## Application for a Non-Material Amendment Following a Grant of Planning Permission

Single storey kitchen pitched roof with exposed kitchen extract to be removed, and new brickwork wall with timber windows and parapet upstand to conceal flat roof over installed to match in with existing elevation

NON MATERIAL AMENDMENT
PROPOSED SIDE ELEVATION
SCALE 1:100

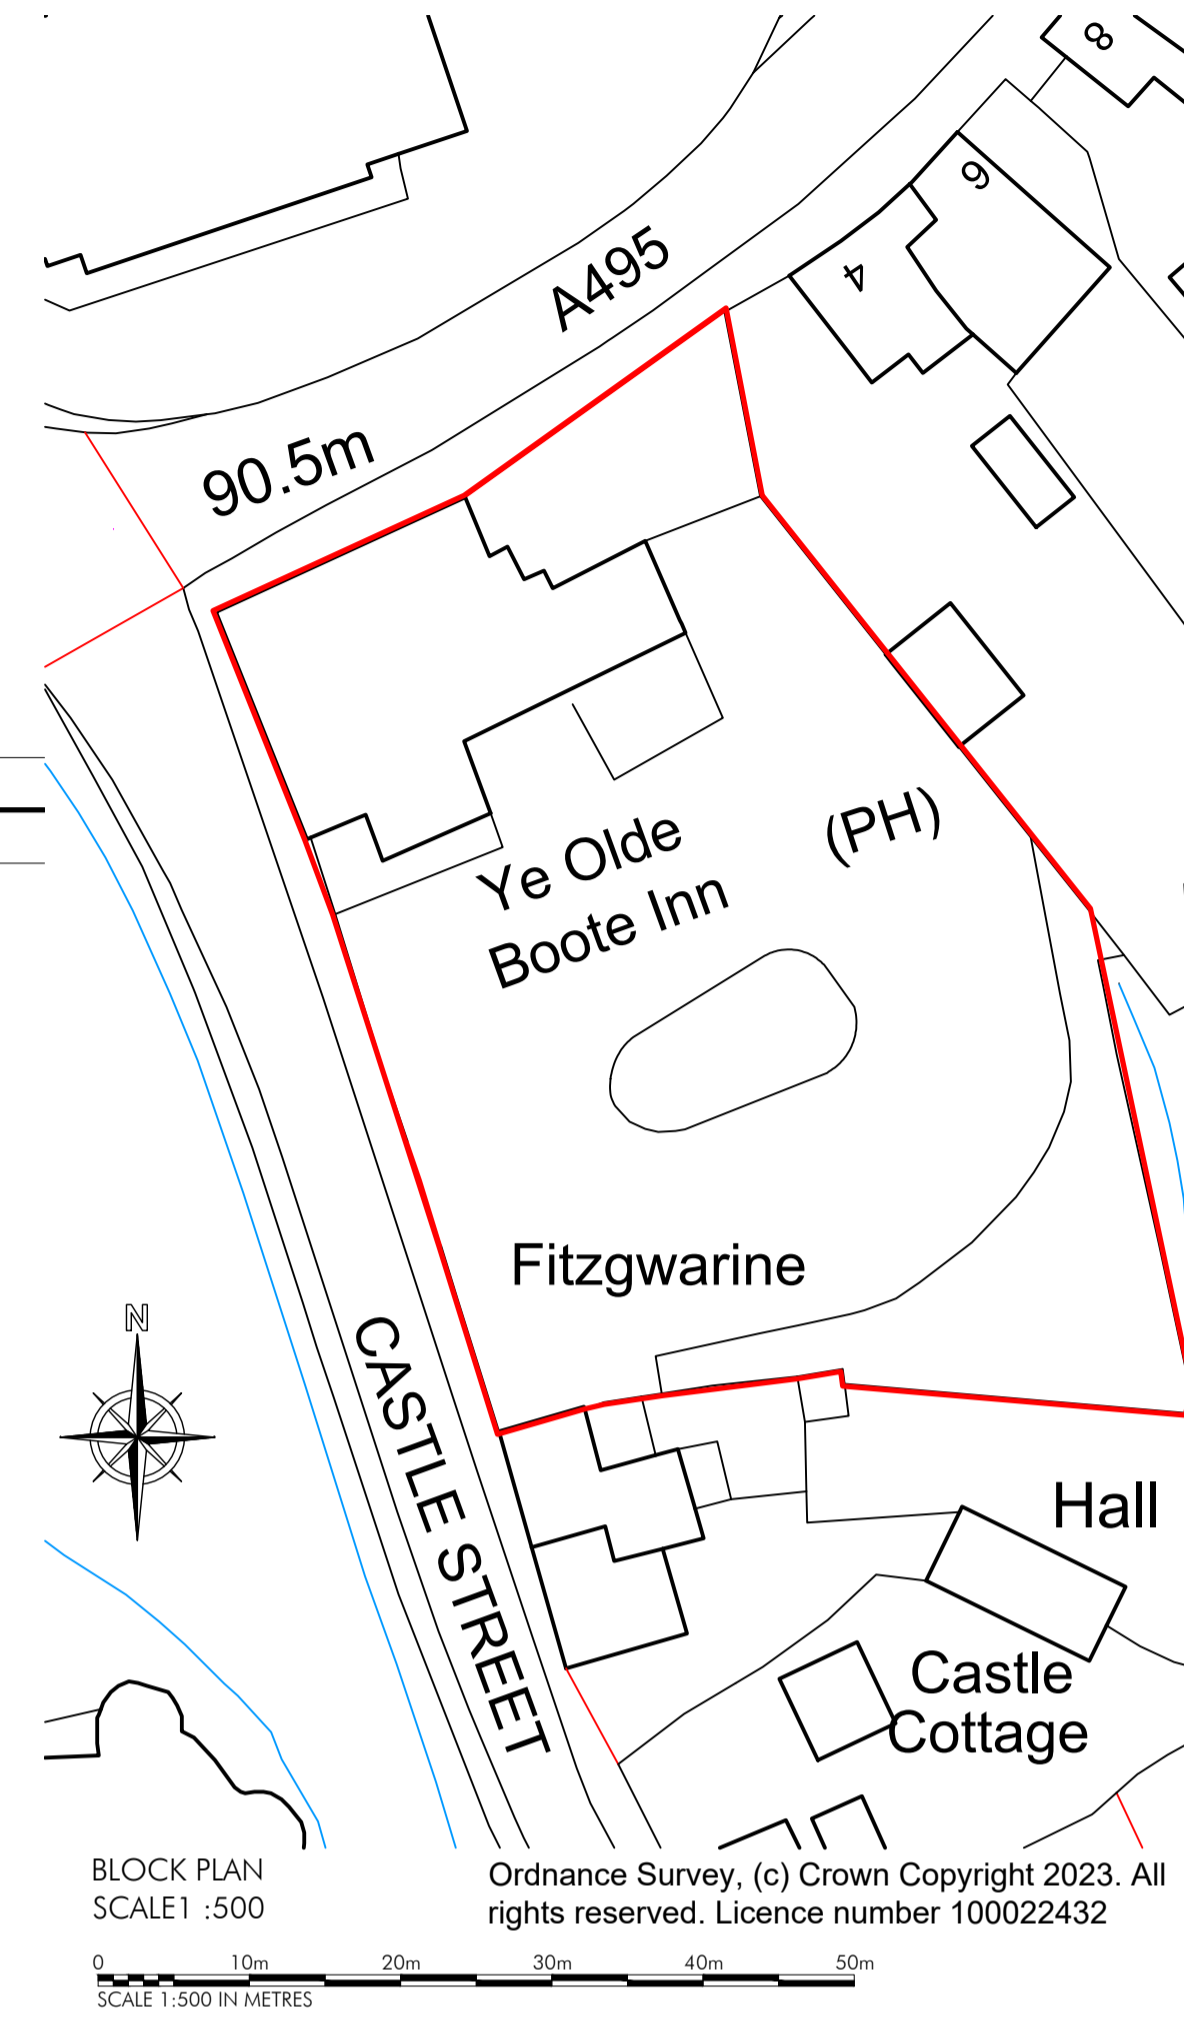
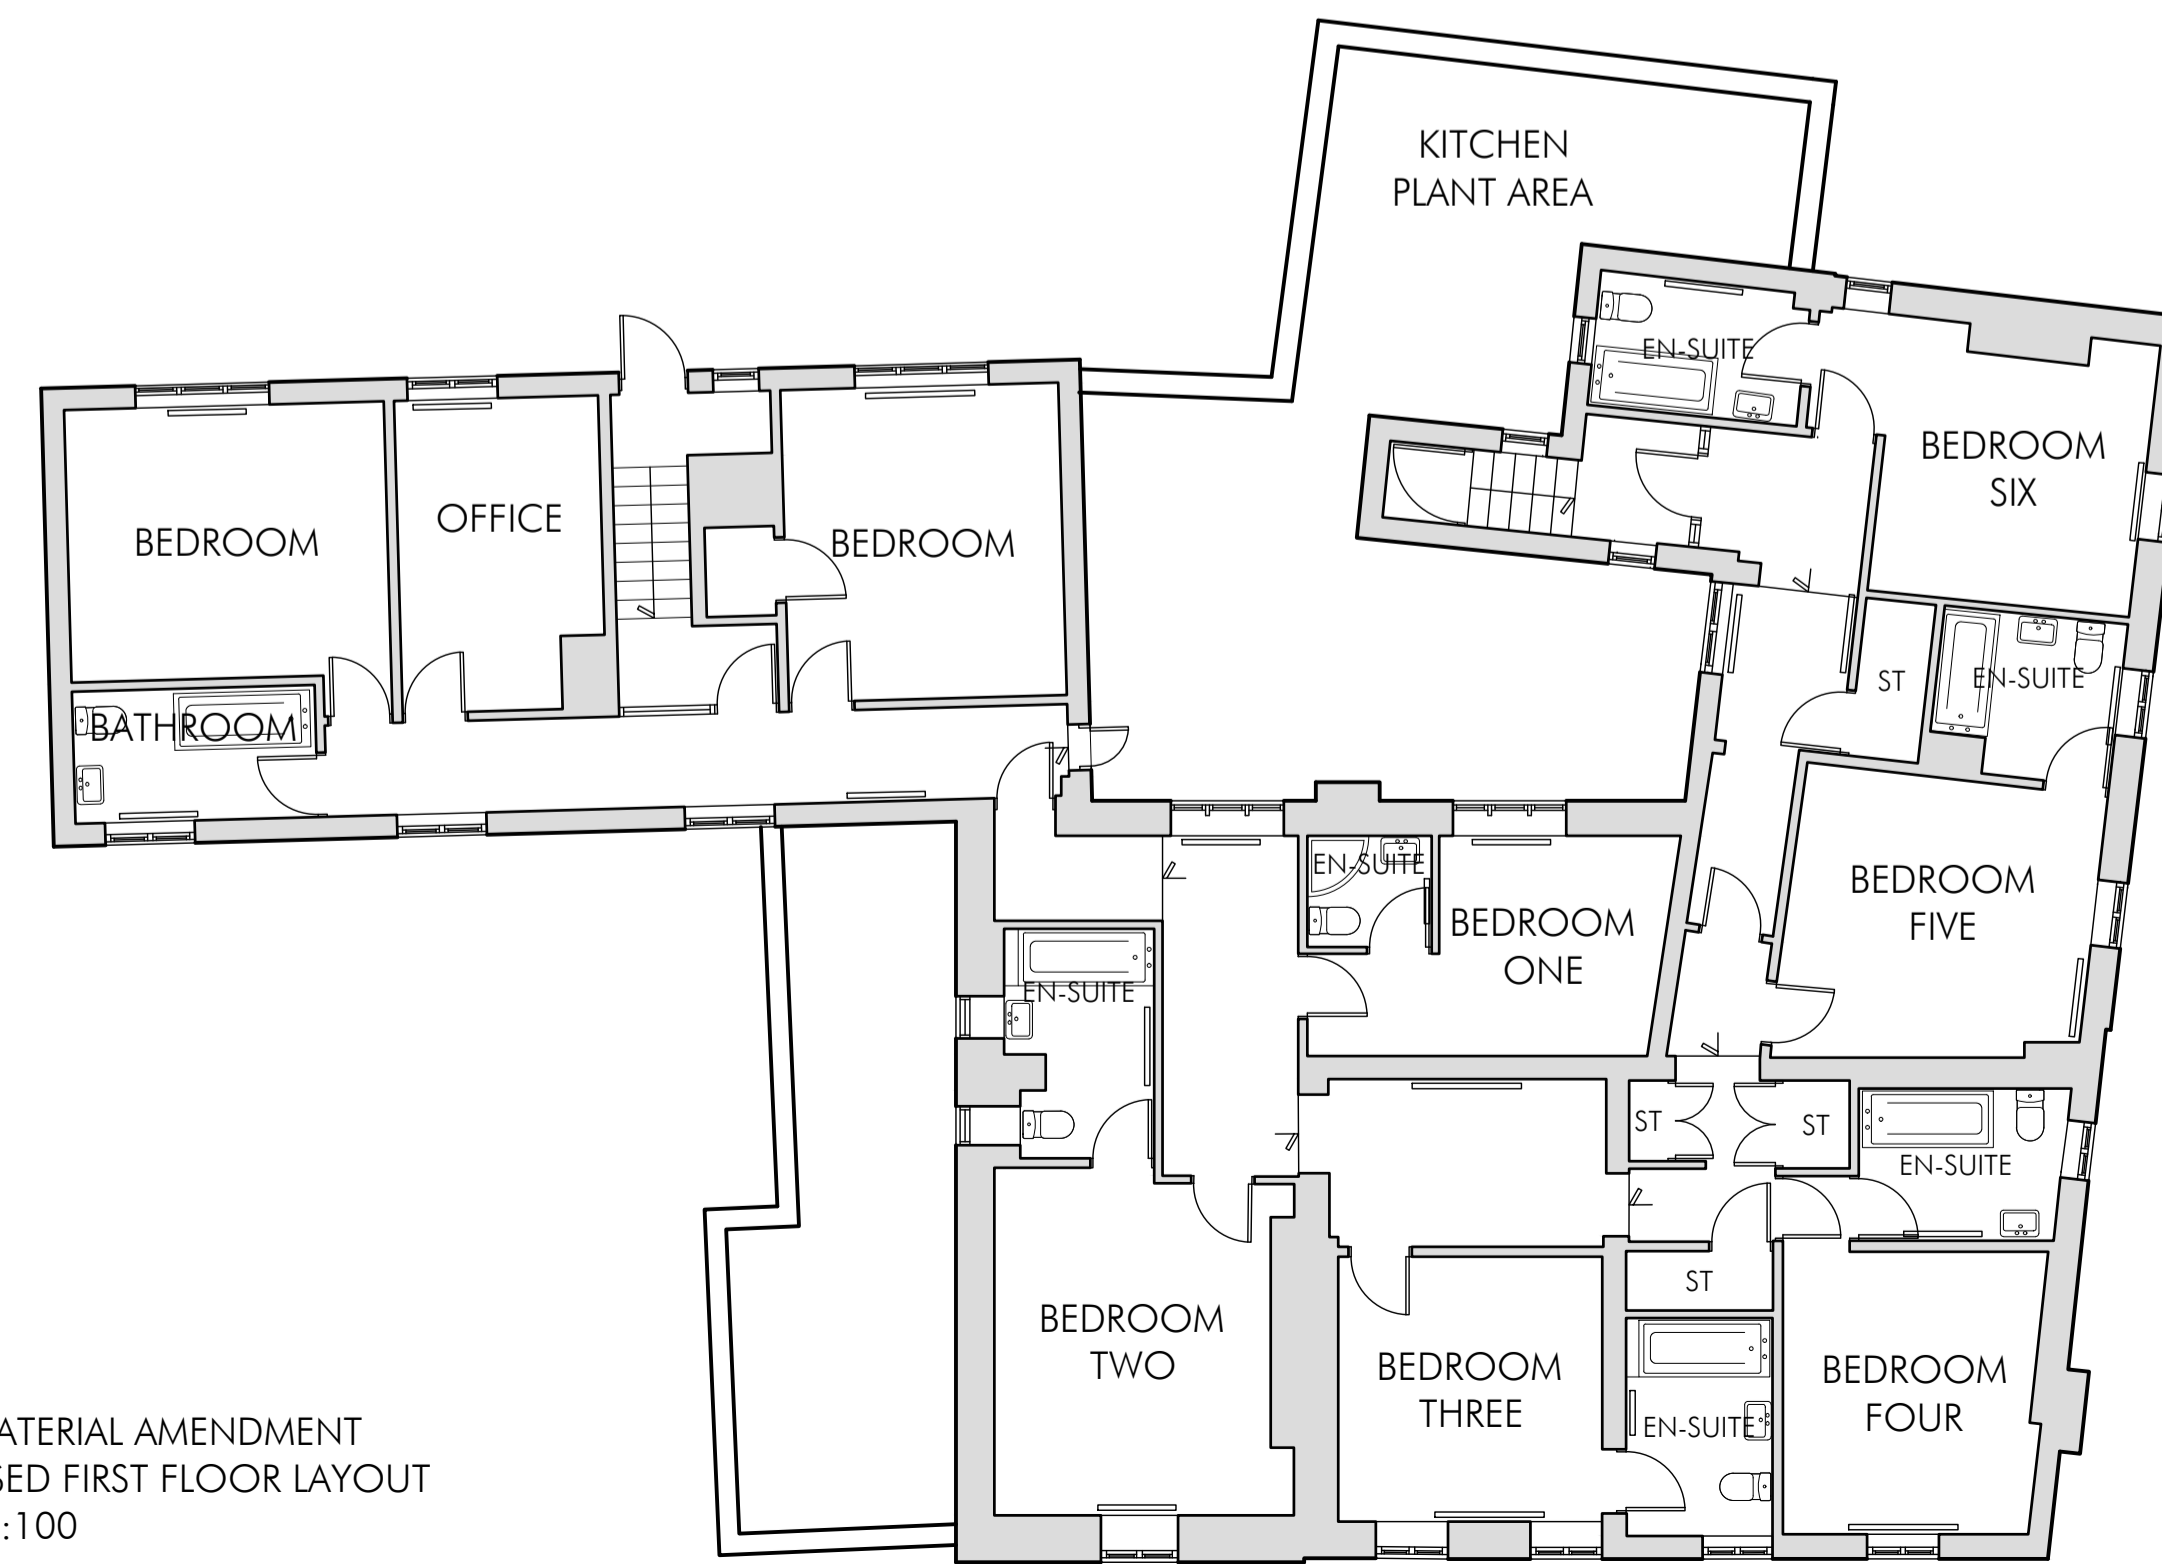
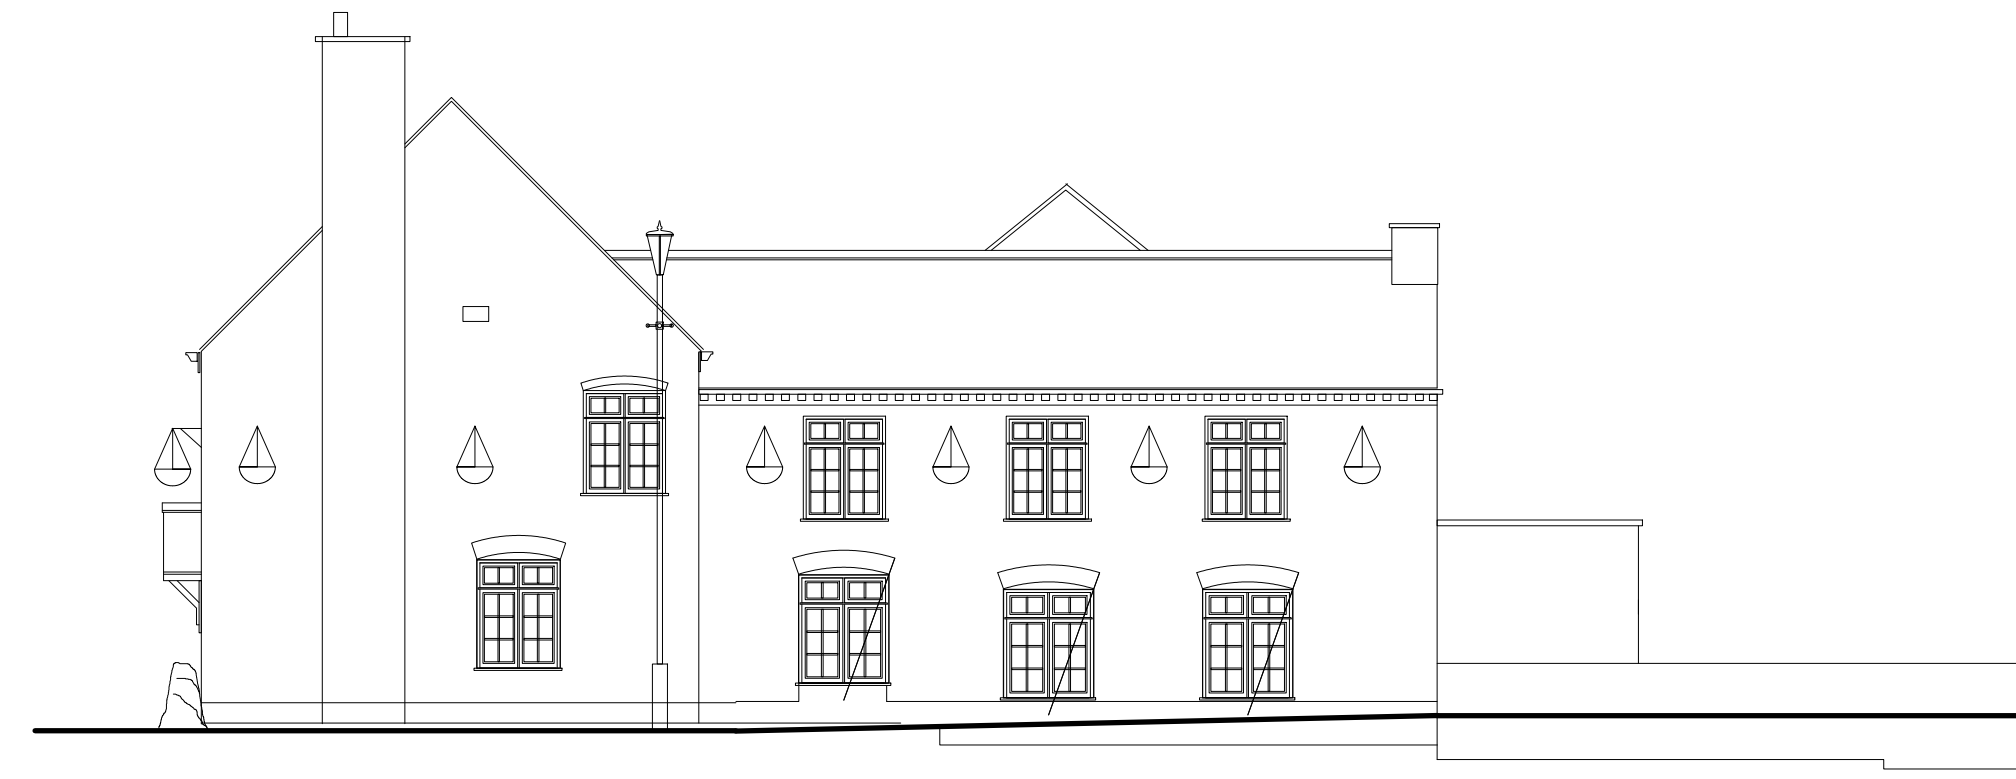
1no Door was removed from Side Elevation,  
2no windows removed from the Rear Elevation  
1no Door opening added to the Rear Elevation

To allow ramped access from the carpark into the public house
